Project Name: NORTH ALBUQ. ACRES UNIT B

**CITY OF ALBUQUERQUE
PLANNING DEPARTMENT
Development Review Board
March 24, 2004 Comments**

PROJECT # 1003299

RE: Lot 16A, Block 18, Tract A, N.A.A. Unit B/SPBP

DRB AS-1

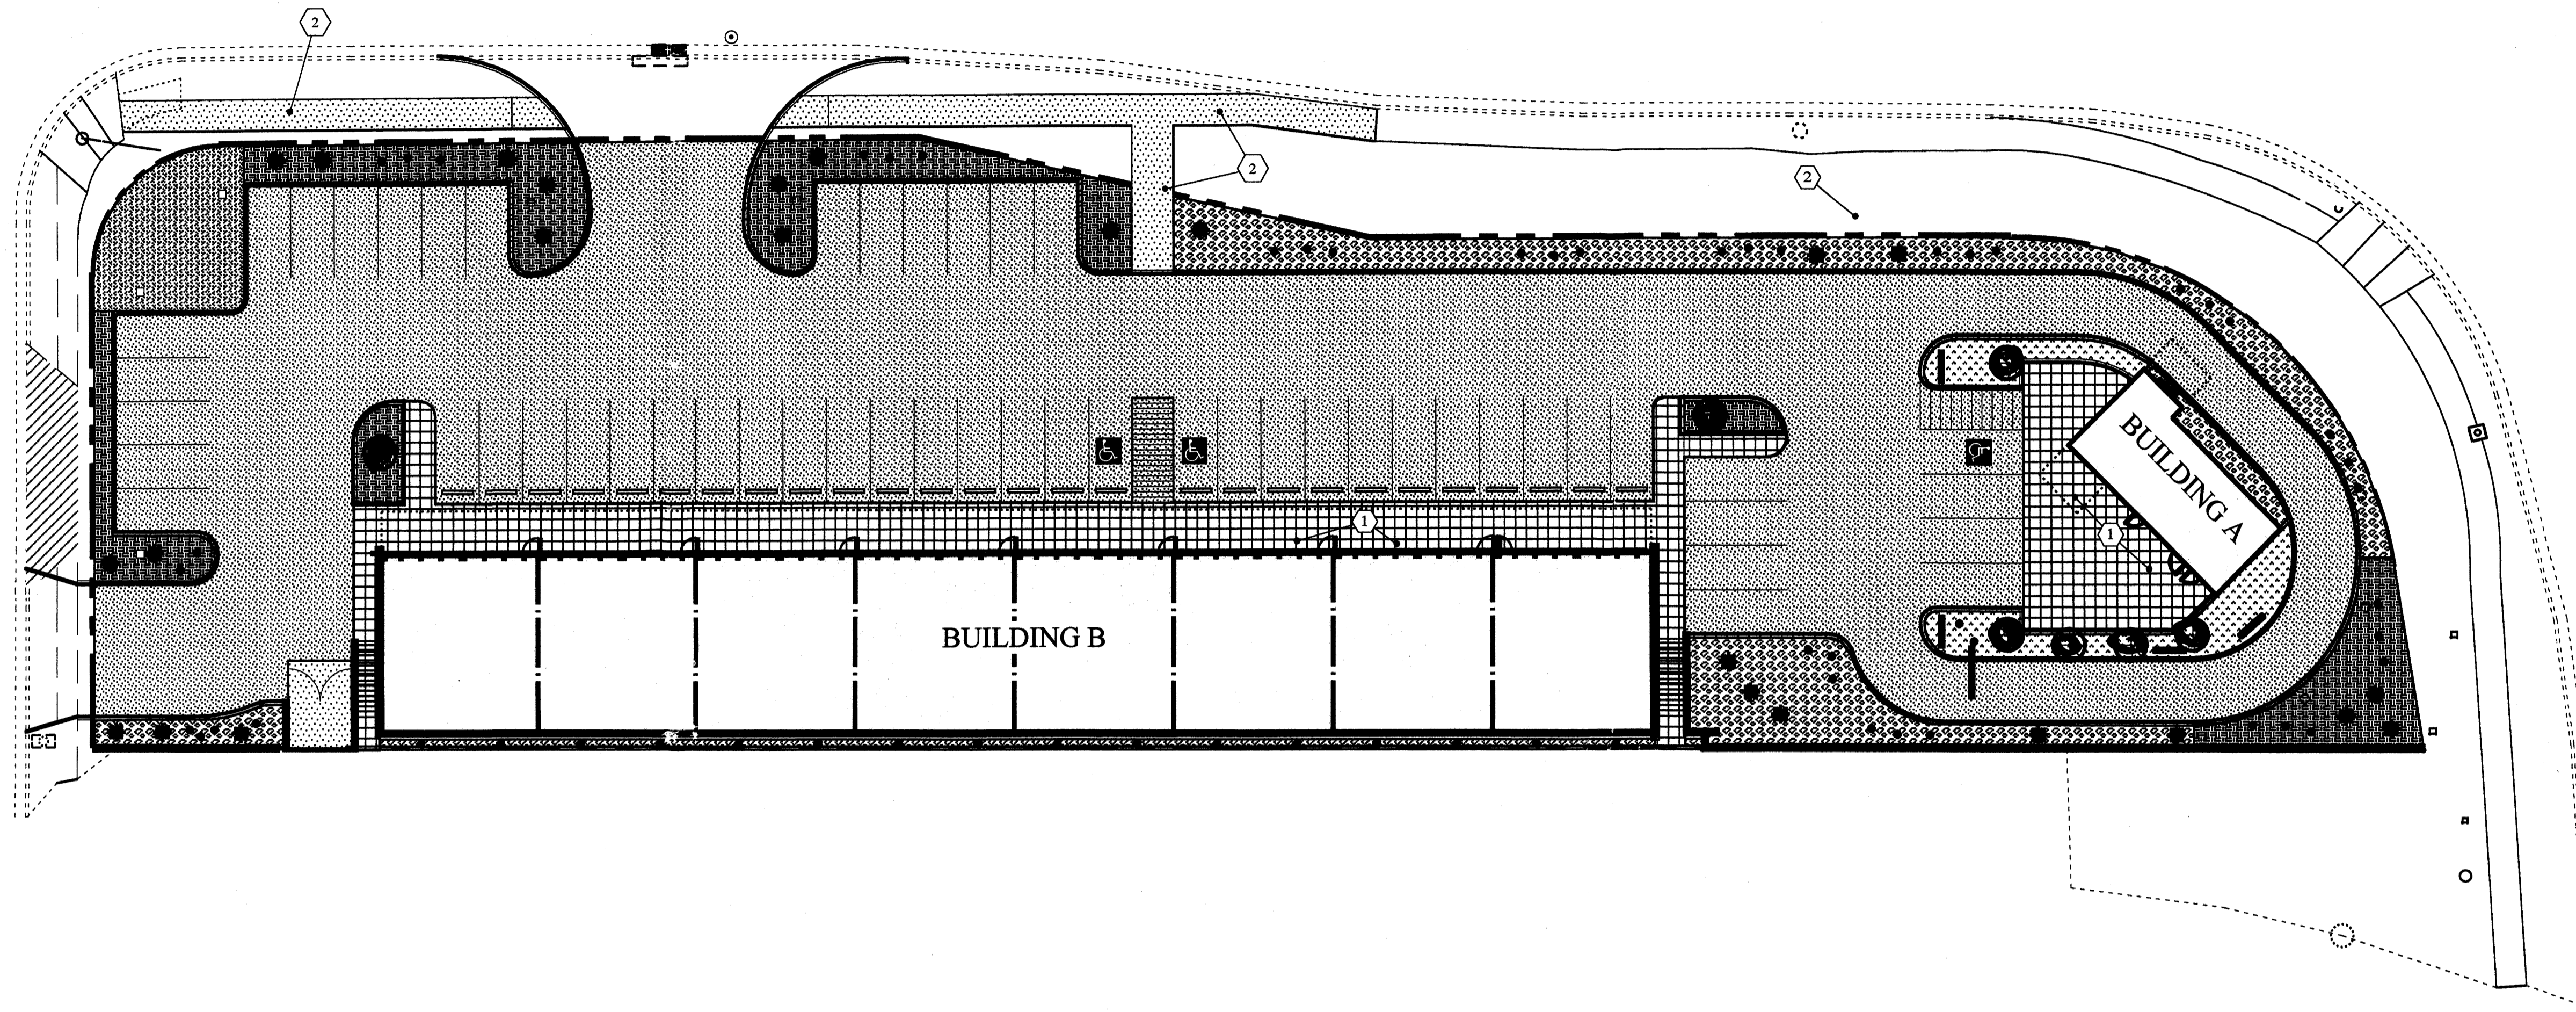
The first sheet with the signature block on it should be labeled "Site Development Plan for Building Permit" as that is what you put on your application.

The bar scale is missing from the site plan sheet. The proposed use for each structure must be identified on each footprint.

The setbacks are to follow the requirements of the IP zone in the Zoning Code. It was not possible to determine what the proposed setbacks are on the site plan.

LANDSCAPE PLAN

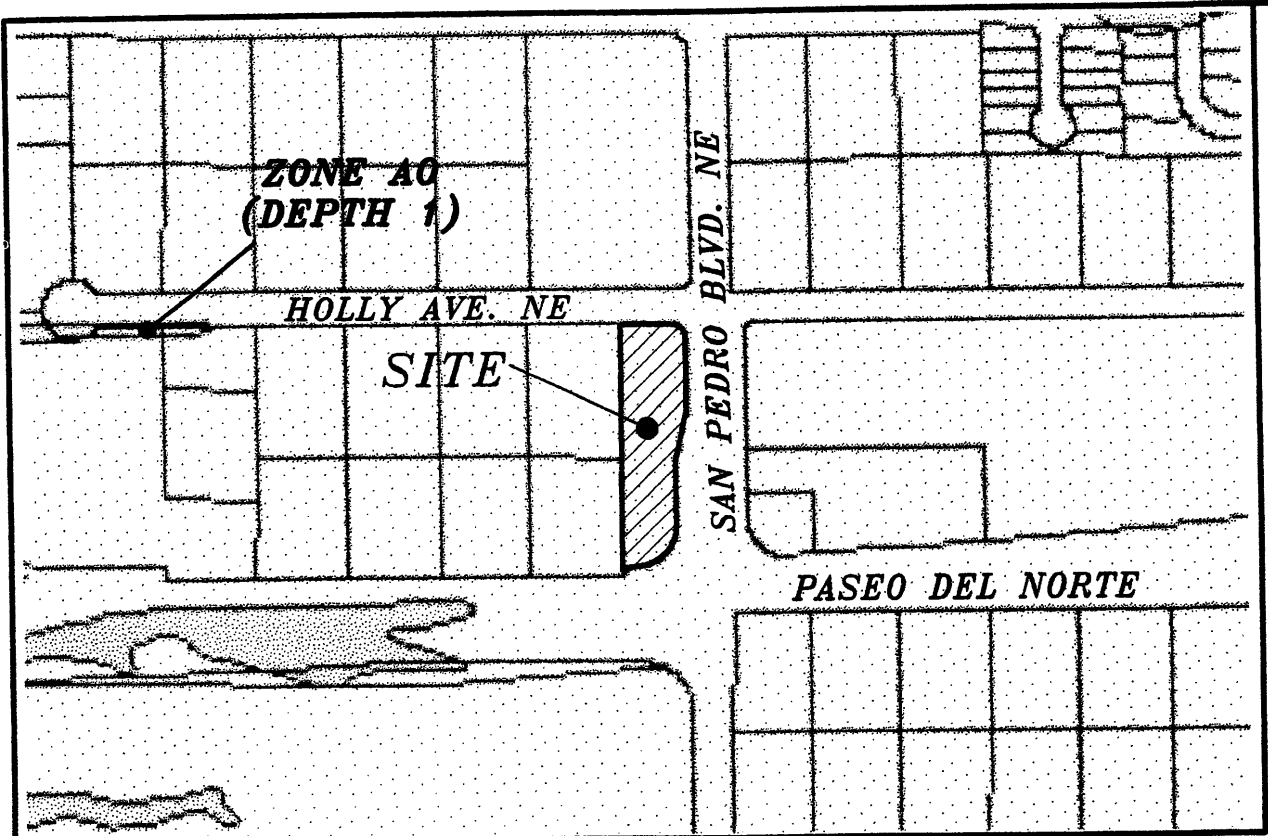
Landscape Plan. There is no bar scale, North arrow, or property lines delineated. Existing & proposed easements are missing. Irrigation system is to be described. Square footage of each bed is required. Square footage and percentage of turf area is required with 20% max. Maintenance responsibility for landscaping is required. Statement of compliance with Water Conservation...Ordinance, See Article 6-1-1. Plants used must have water usage identified by H,M, L. The percentage of landscaping provided is missing.

Many of the requirements of the Landscape Plan in the North I25 Sector Plan are not met with this submittal. See pages 54 & 55 of that plan.
